Comments for Planning Application 21/00347/VAR

Application Number: 21/00347/VAR

Address: 312A Woodstock Road Oxford OX2 7NR

Proposal: Variation of condition 7 (Details - Front Garden) of planning permission 20/02631/FUL (Demolition of existing bungalow. Erection of 2 x 4-bed dwellinghouses. Provision of bicycle and bin stores and associated landscaping.) to allow additional car parking.[cr]

PROJECT 312a Woodstock Road	
DRAWING Proposed Plans	
SCALE @ A1 1/100	SCALE @ A3 1/200
DRAWING No. 348 / P / 003	REVISION No. E

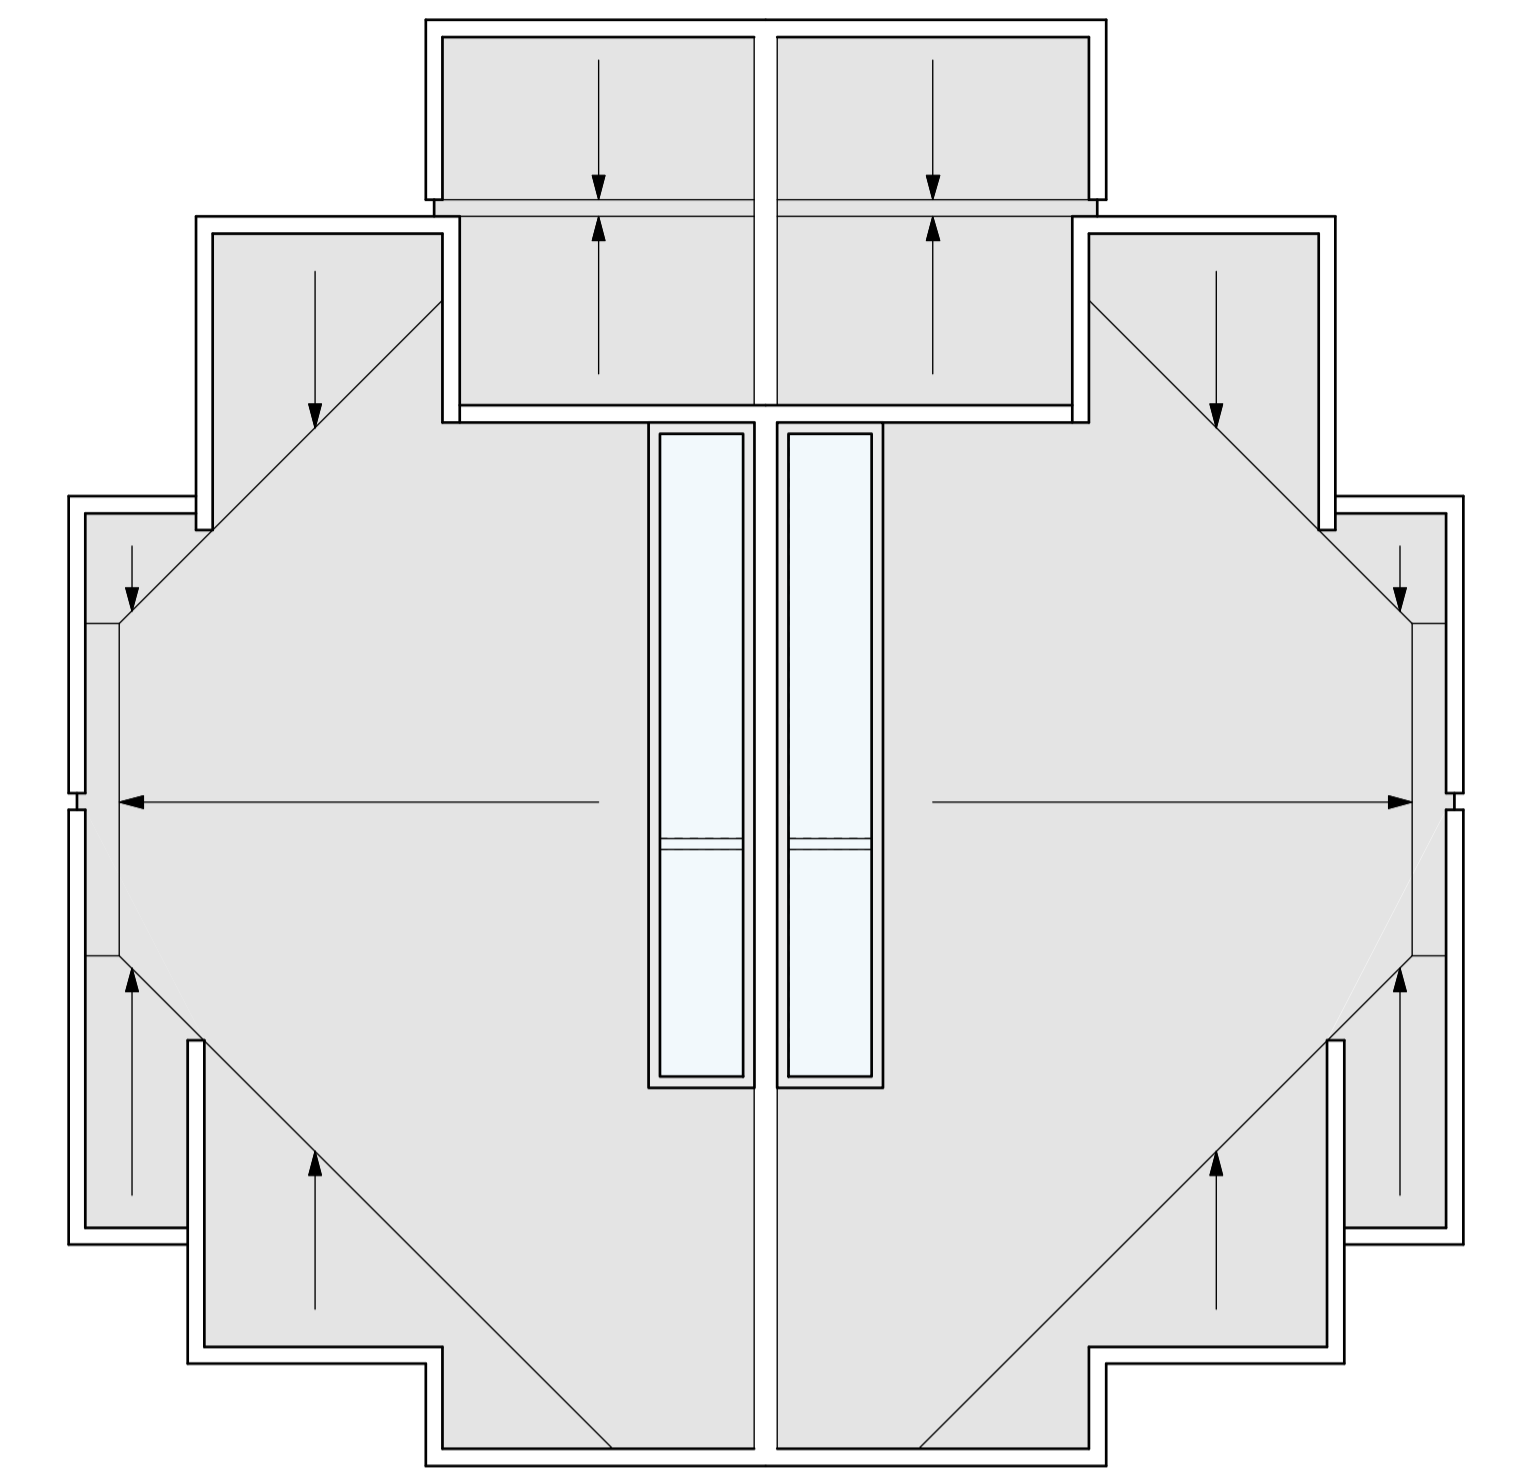
The original application claimed that it would make the access lane "more spacious and less squeezed and cars would not be manoeuvring awkwardly in the tight space in front of 312B, so their amenity will be improved". However, if a car is parked in front of house # 2, that space will be unavailable for any other vehicle wishing to turn around, making the whole of the previous claim invalid.

On all these grounds, therefore, I strongly object to planning permission being granted for a second car parking space in front of the new pair of houses.
